Our Case Number: ABP-317660-23

Re: Bus Connects Kimmage to City Centre core bus corridor scheme
Kimmage, Dublin

KIMMAGE TO CITY CENTRE CORE BUS CORRIDOR SCHEMELANDSCAPING AND URBAN REALM

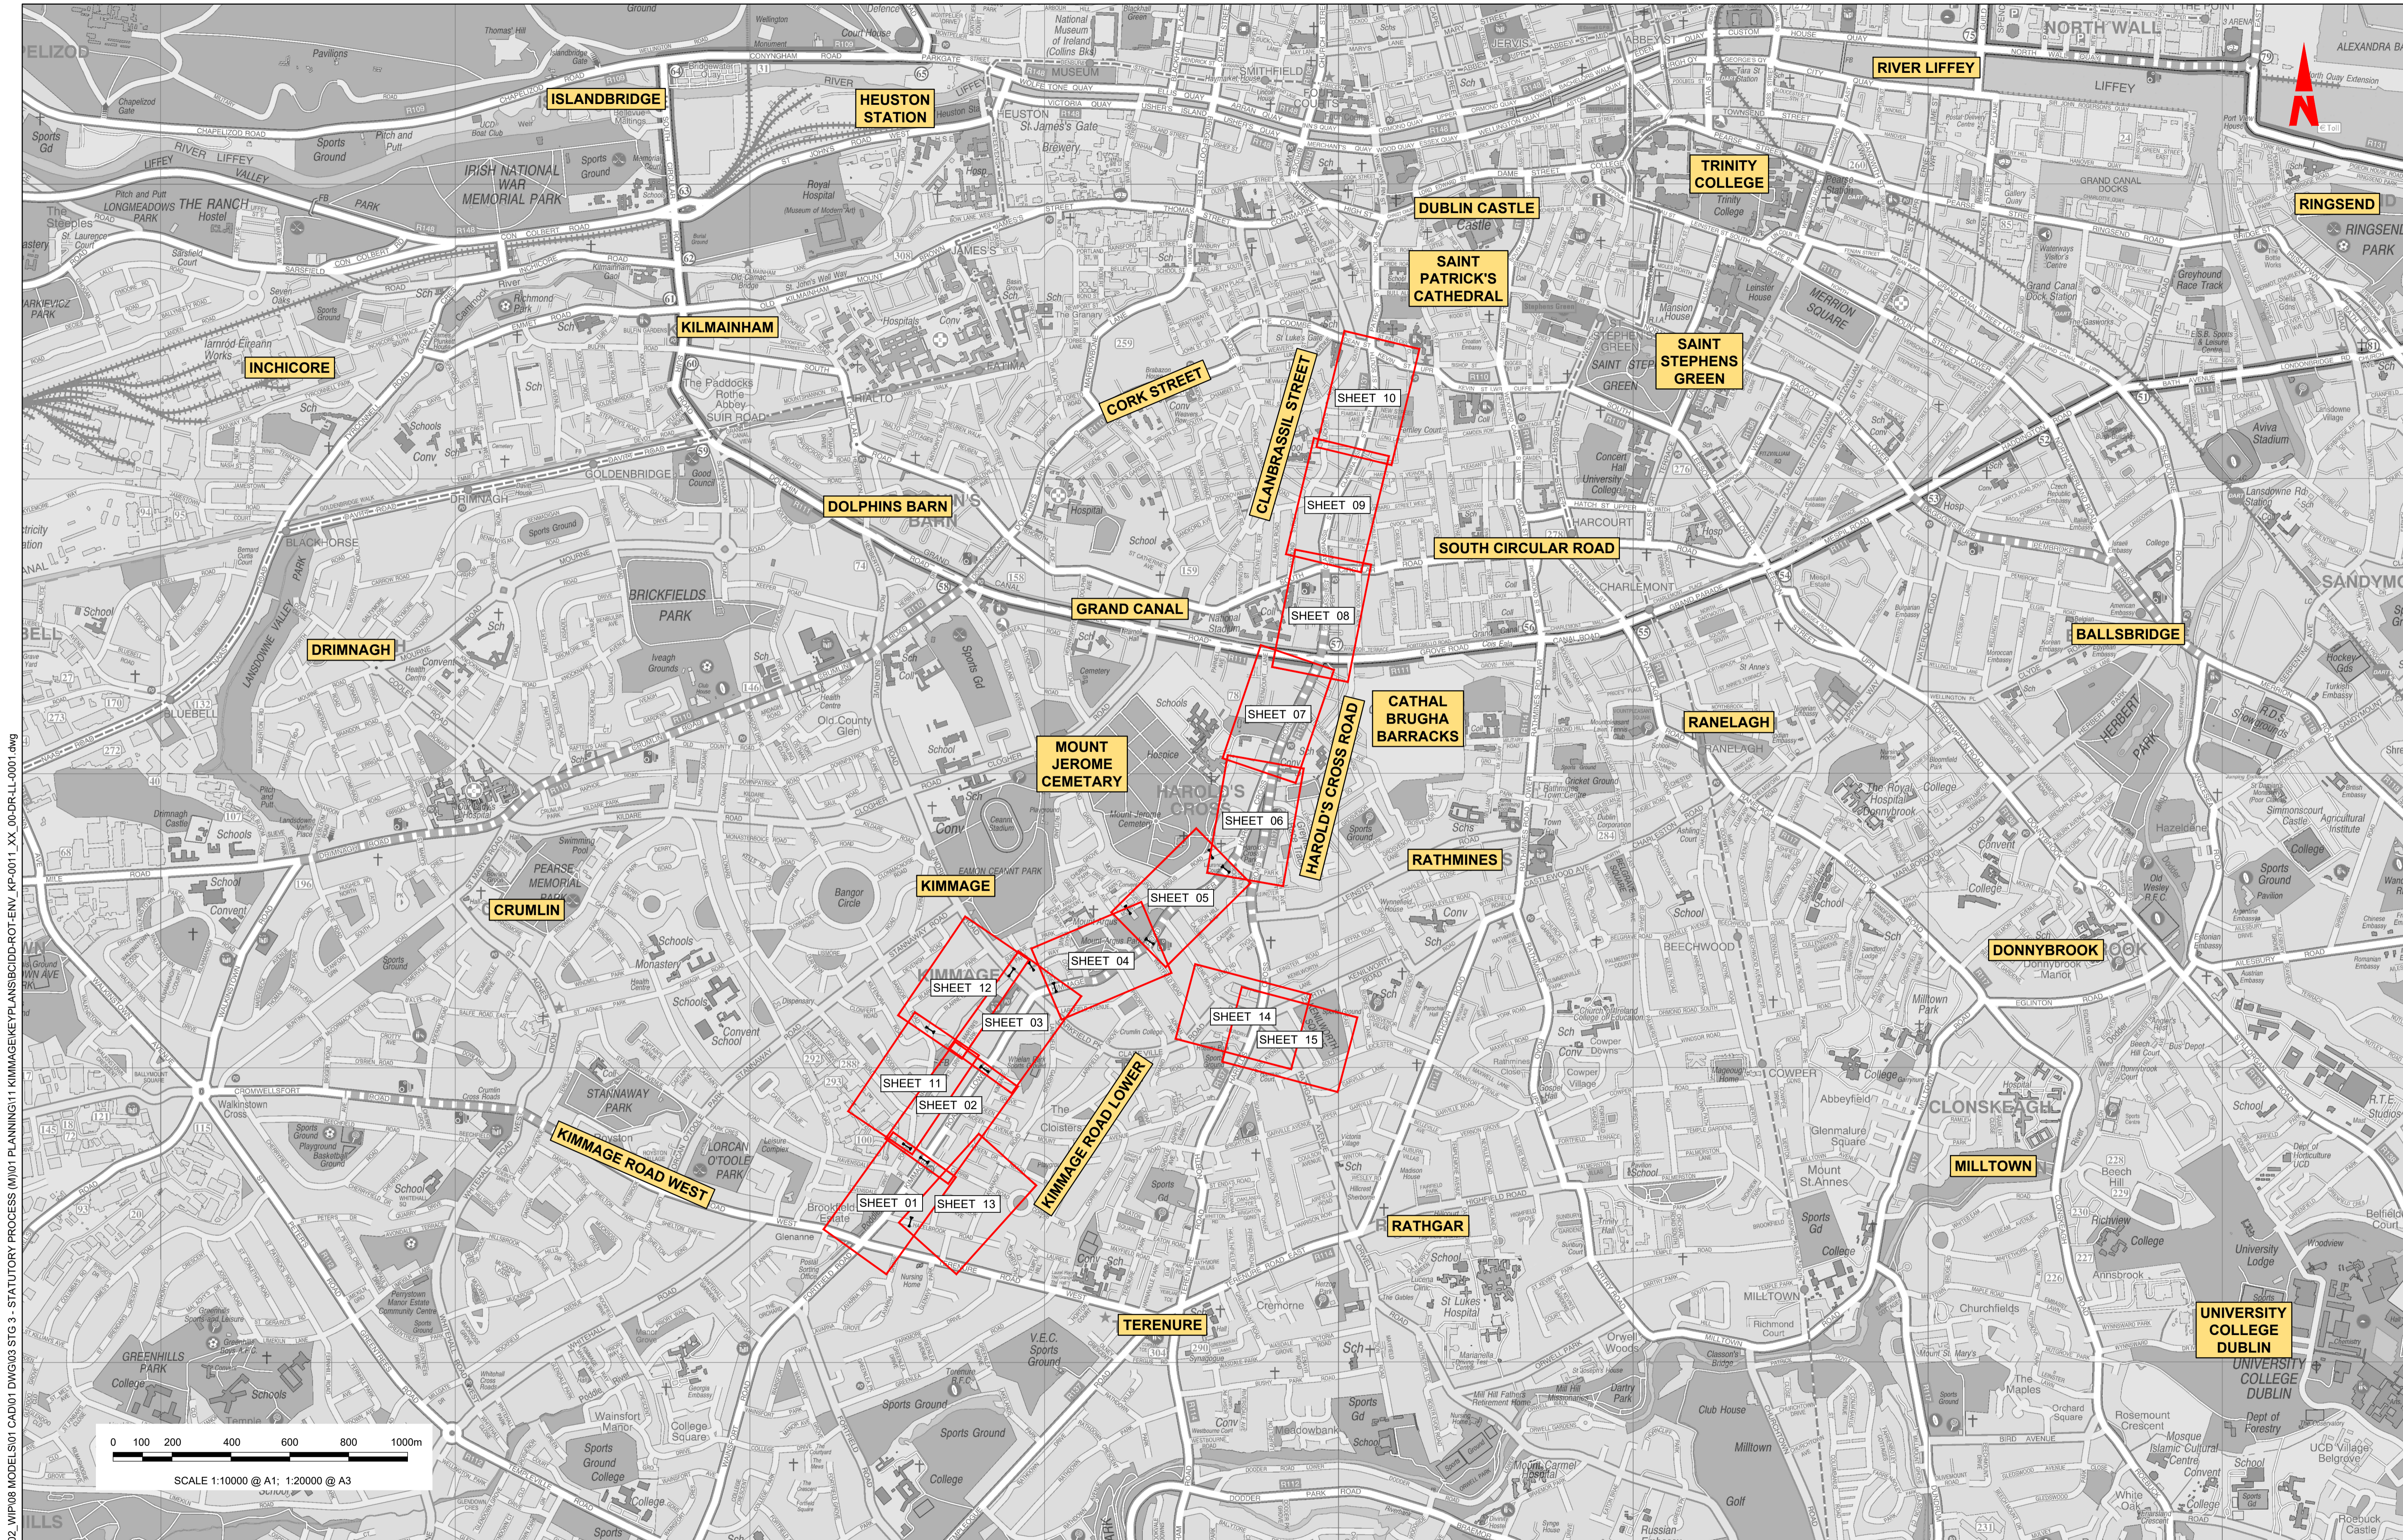
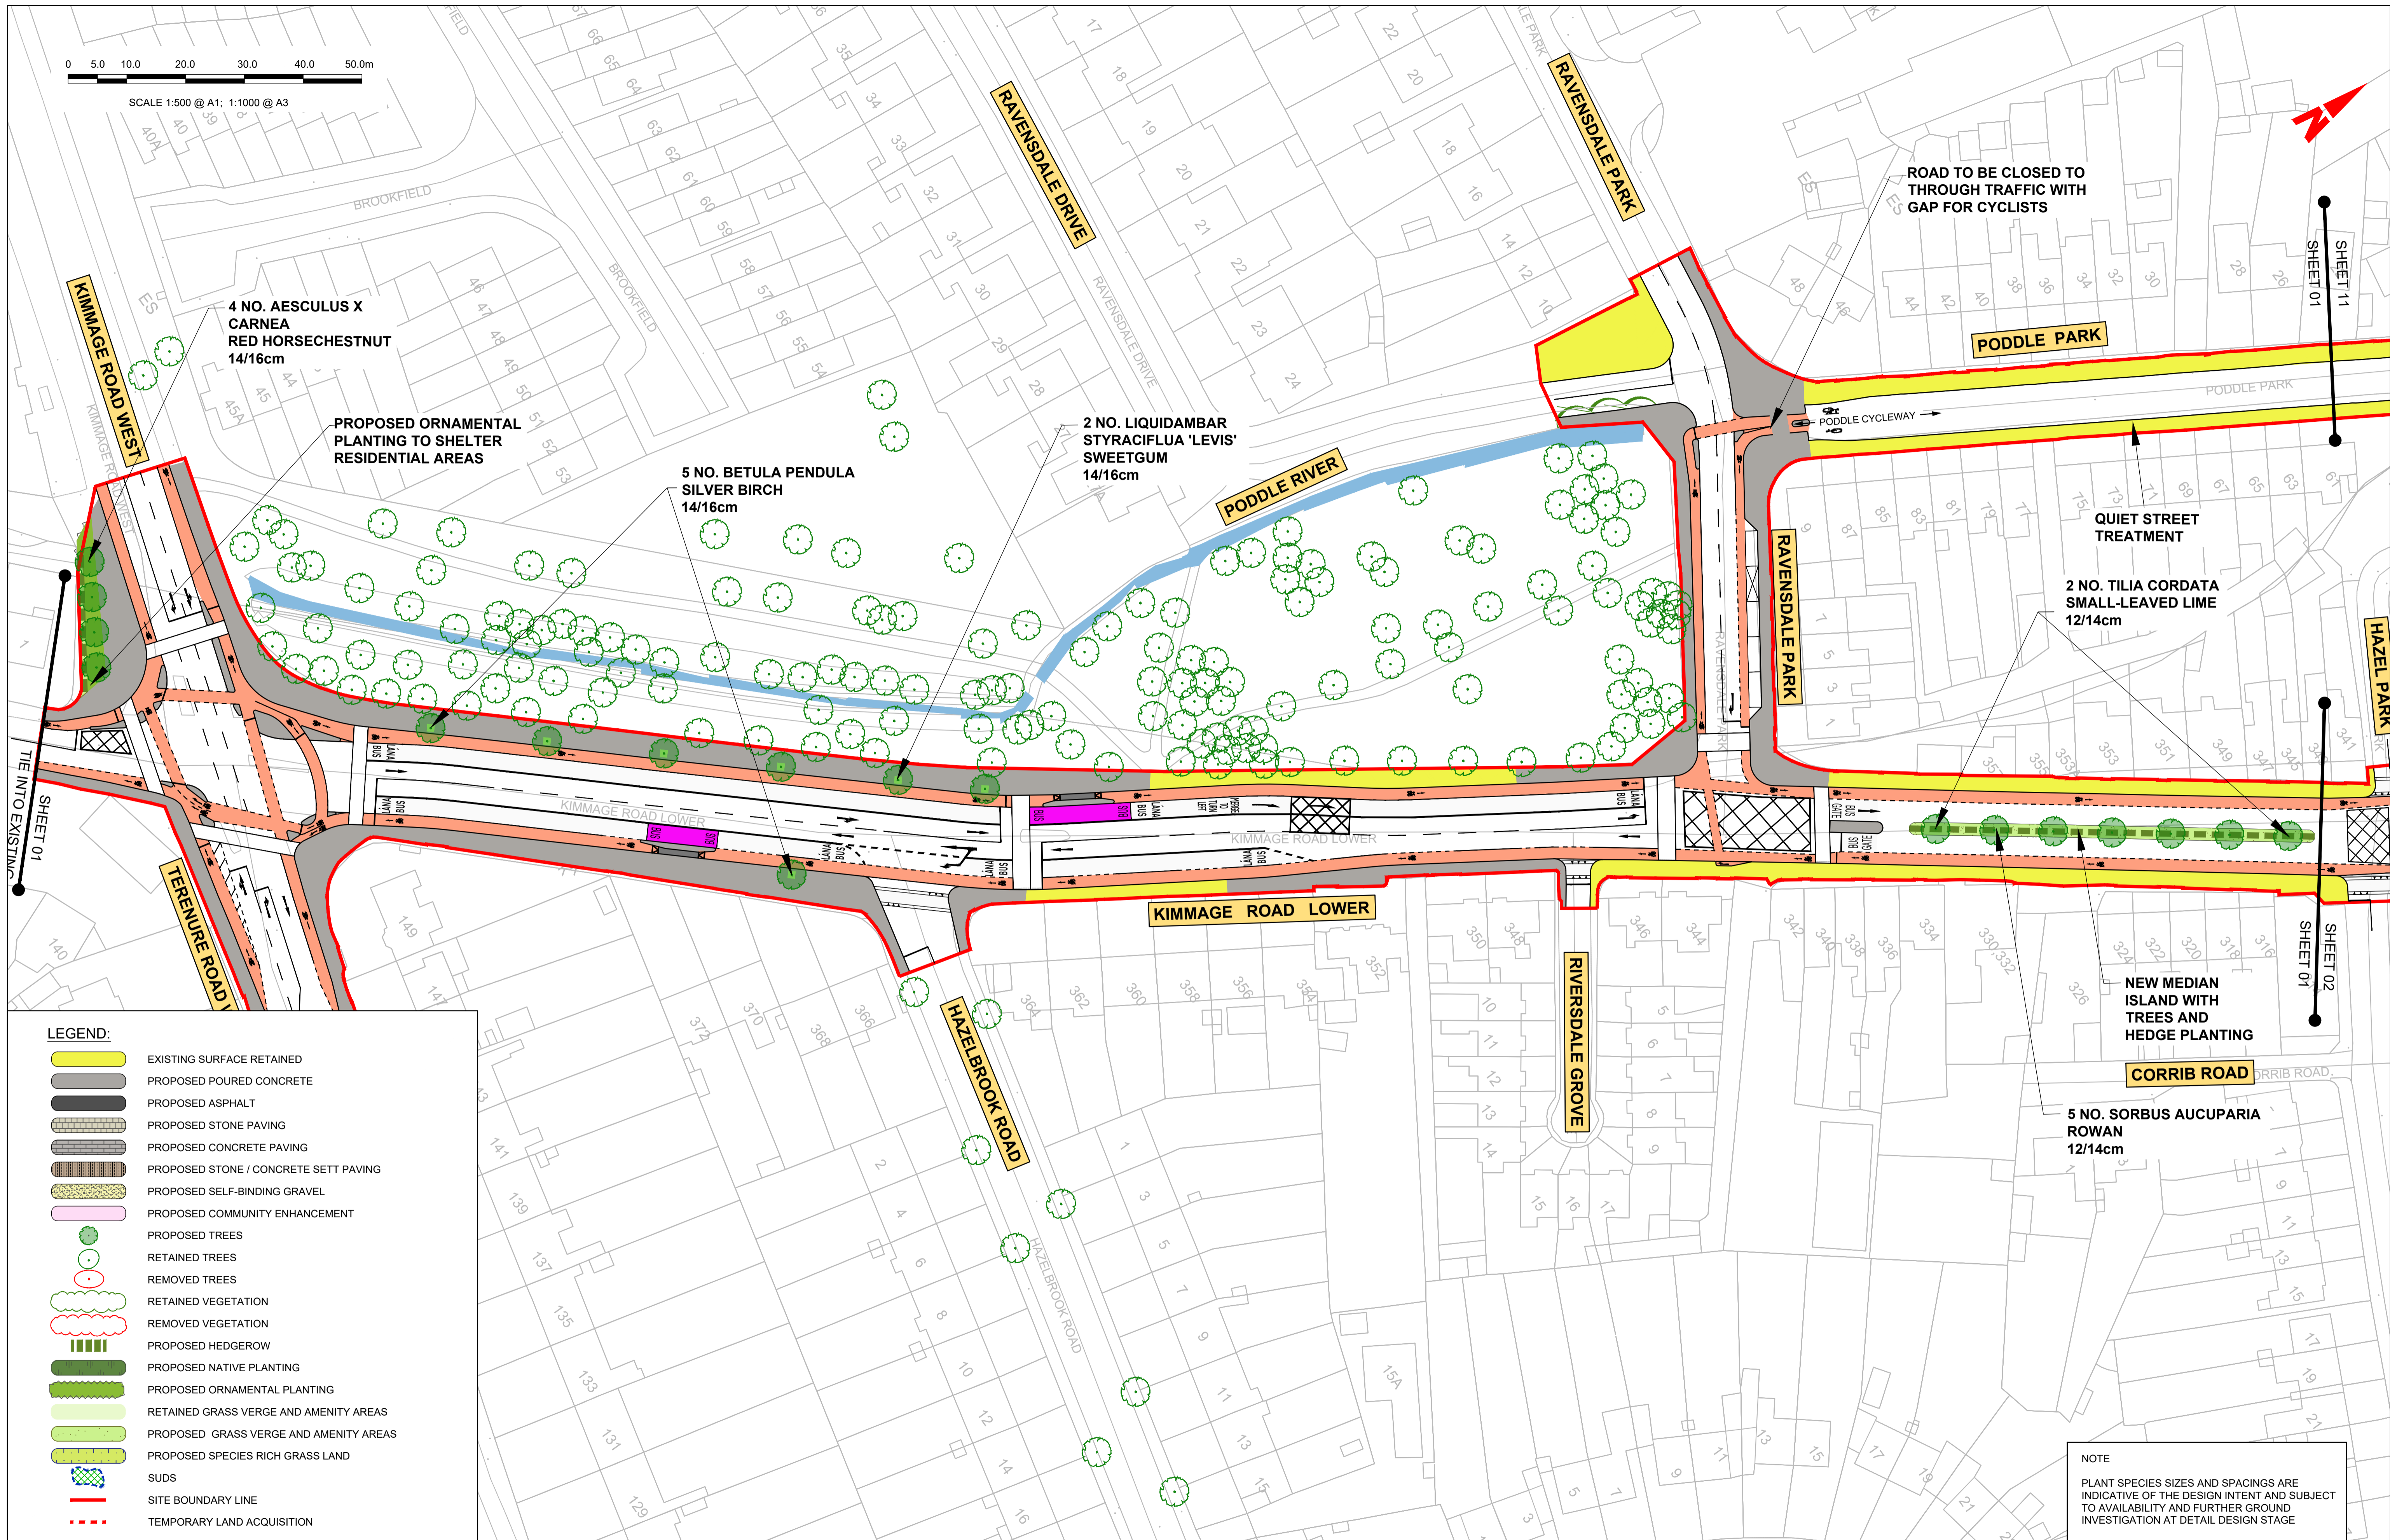
BCIDD-ROT-ENV_LA-0011_ML_00-DR-LL-0001- 14 Sheet 1 of 14 (general note to entire route)

More ambitious provisions of new trees should be provided while works are underway to promote sustainability. Existing trees outside boundary line of works have been included which suggest more trees are being installed than it appears until legend is read. Works outside red line is not relevant and they should be not be included on the application as it appears to overstates trees actually being provided.
